Interested Party Reference: ██████████ **Project:** One Earth Solar Farm (EN010159)
Submission Type: Written Representation in Response to the Secretary of State's Consultation Letter dated 21 May 2026 (Requesting Responses to the Post-Examination Submissions Regarding Draft Requirements 7 and 22)

SUBJECT: Material Non-Compliance, Administrative Failure, and Fraudulent Substitution of Regulatory Baselines in the Outline Battery Safety Management Plan (oBSMP) Revision 08 (May 2026) [EN010159/APP/7.11.7]

Figure 2.1: Illustrative Layout West BESS Site

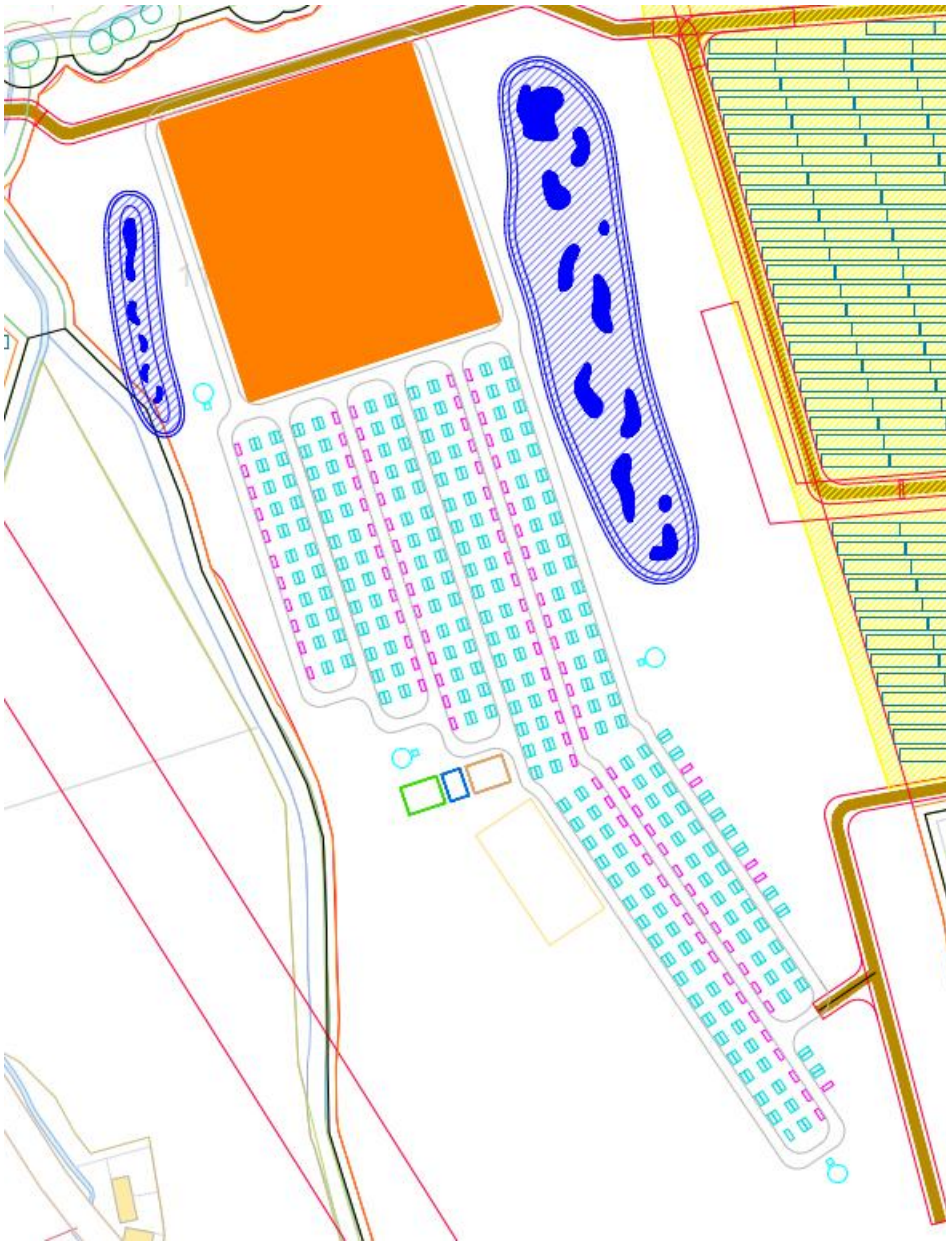
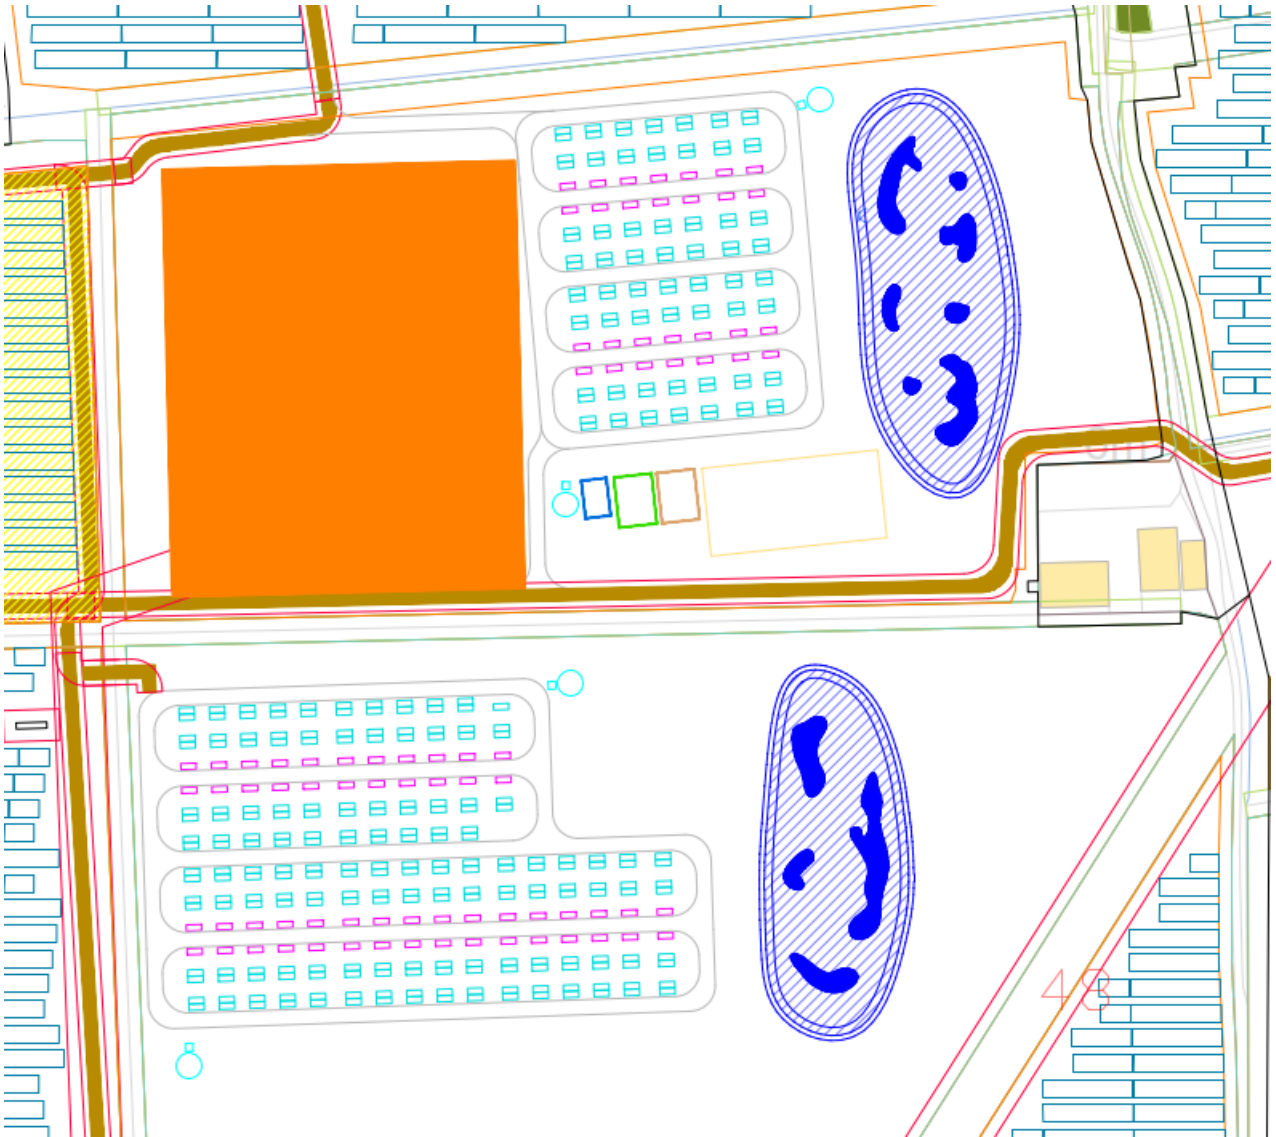
By choosing to ignore active 2025/2026 NFCC and international (NFPA 855) safety floors, the Applicant's illustrative layout introduces extreme physical hazards to the site boundaries:

- **The 0.15-Metre Back-to-Back Spacing Floor Breach:** Current standards dictate an absolute minimum physical floor of 0.914 metres (3 feet) between battery enclosures—and then only if backed by full-scale UL 9540A fire testing. Table 1.1 (Ref 2) admits the applicant's layout features a back-to-back separation of just 0.15 metres (less than 6 inches). This 83% reduction below the absolute regulatory floor creates an unacceptable risk of catastrophic thermal cascading across battery islands.

- **Occupied Building Encroachment:** Active guidance mandates a minimum 30-metre buffer zone between high-capacity BESS assets and occupied properties. Table 1.1 (Ref 6) openly acknowledges that an adjacent working farm is located within 25 metres of the East BESS Site.

- **Vegetation Clearances:** The Applicant arbitrarily slashes the required 10-metre combustible vegetation buffer down to 3 metres, introducing severe wildfire and thermal ignition vectors along the site perimeters.
